## **ATTACHMENT 1**

In order to finalise the Department's assessment, additional information is required including but not limited to the following:

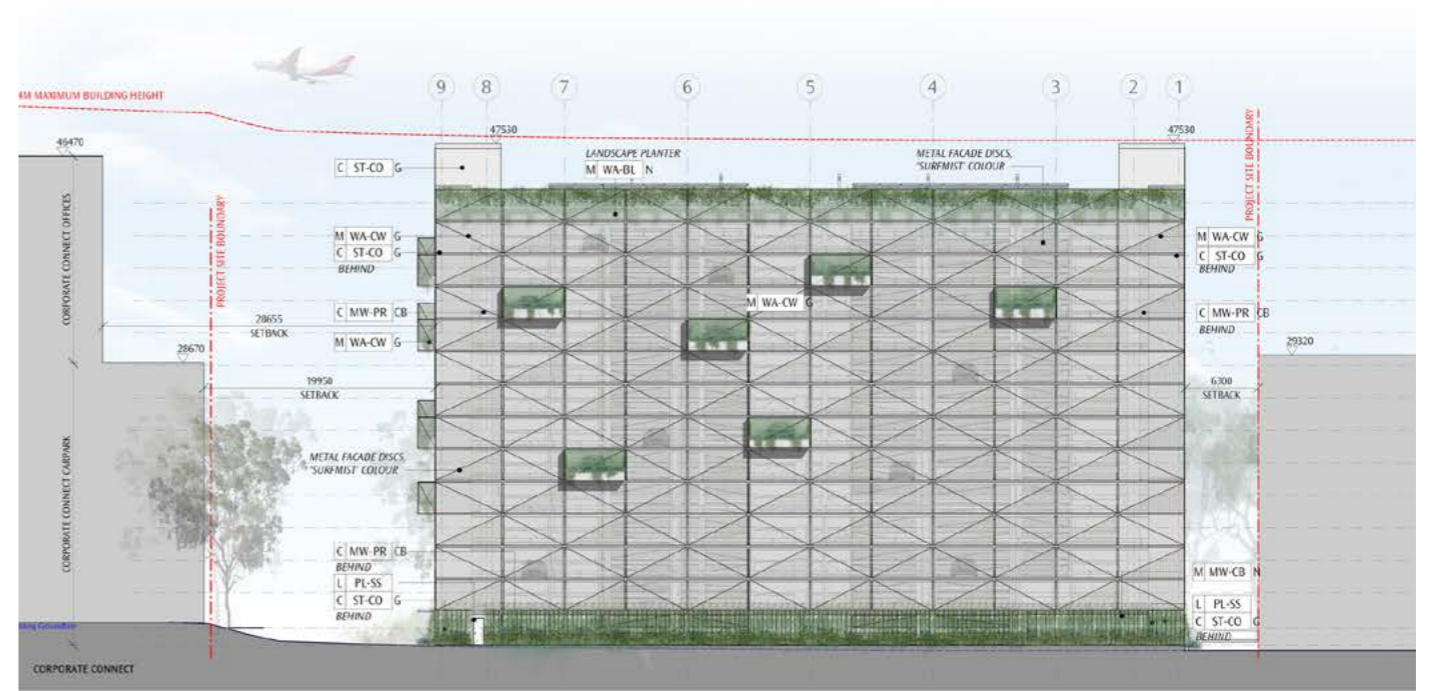
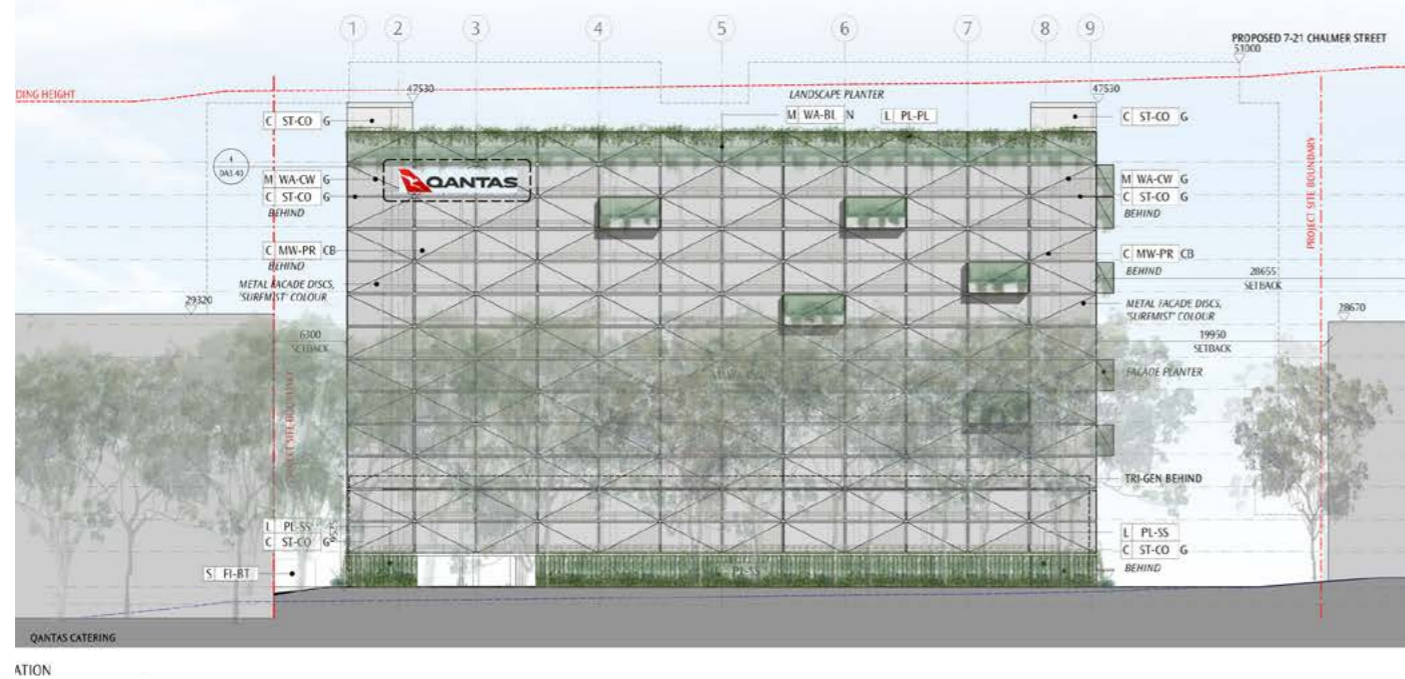
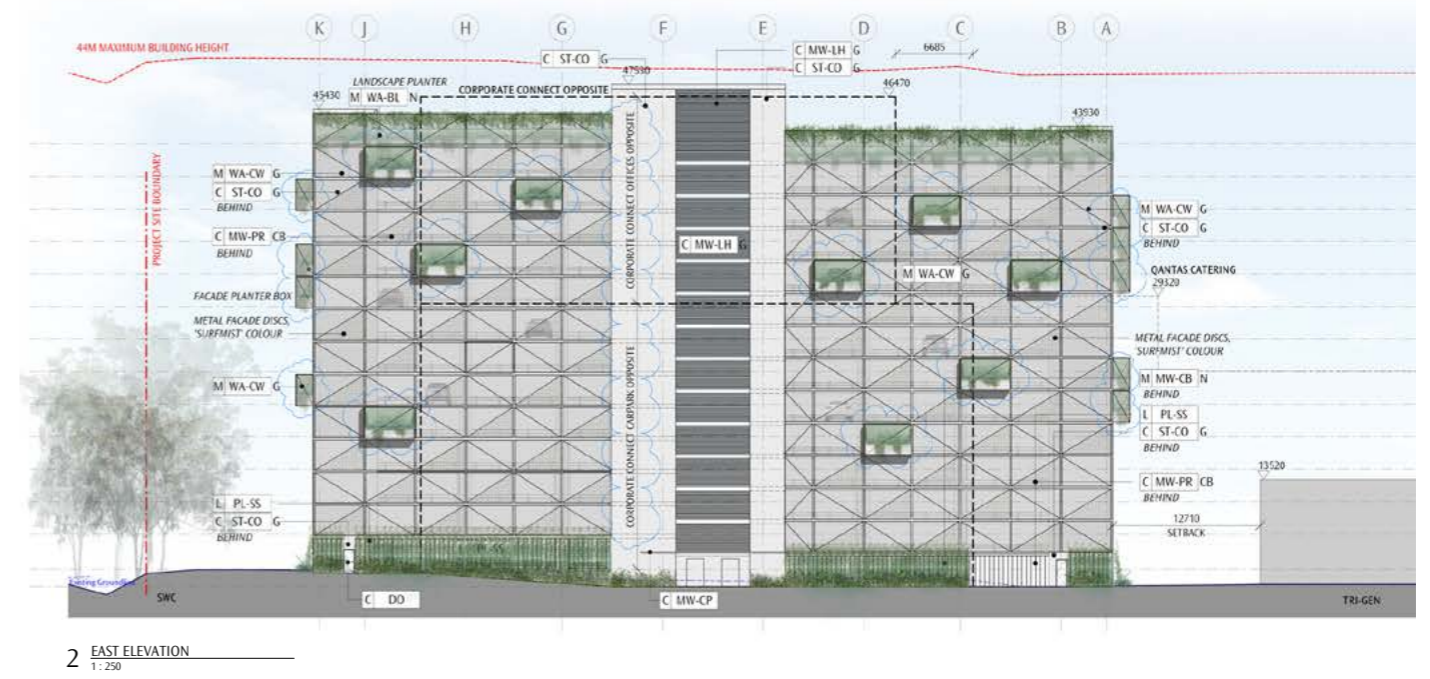
- Further consideration should be given to the use of green wall/green roof designs for both buildings as per the SEARs and the comments from Council and EES (former OEH). Limited green climbing planting is provided on the car park building and insufficient explanation is given as to the reasons why the flight training centre is not able to include these elements.

- Please address the comments provided by Council and EES (former OEH) regarding landscaping. Replacement trees should be advanced to minimise any period of reduced canopy cover whilst they reach maturity.
- Further investigation into green roofs and walls to the car park should be undertaken as a measure of compensating the reduction in trees on site.

1 FE2 - TYPICAL SECURITY FENCE DETAIL  
1:20

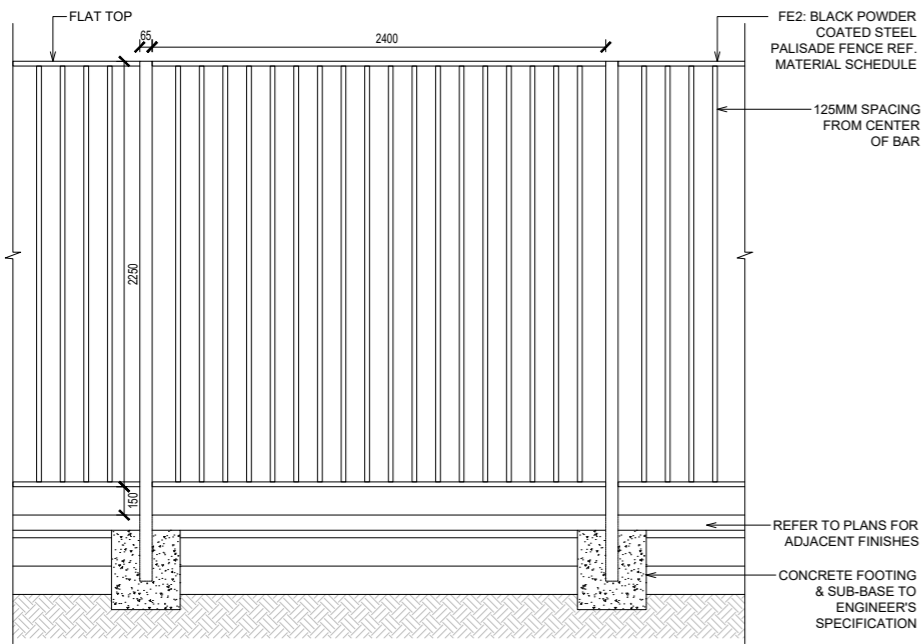
- Further information is required for the security fencing proposed along the southern boundary (King Street). The Architectural Plans (Appendix C – DWG DA5.01) and Visual Impact Assessment (Appendix M – Drawing No. DA07) show predominately open palisade fencing. A fencing plan should be prepared indicating the height and type of fencing proposed.
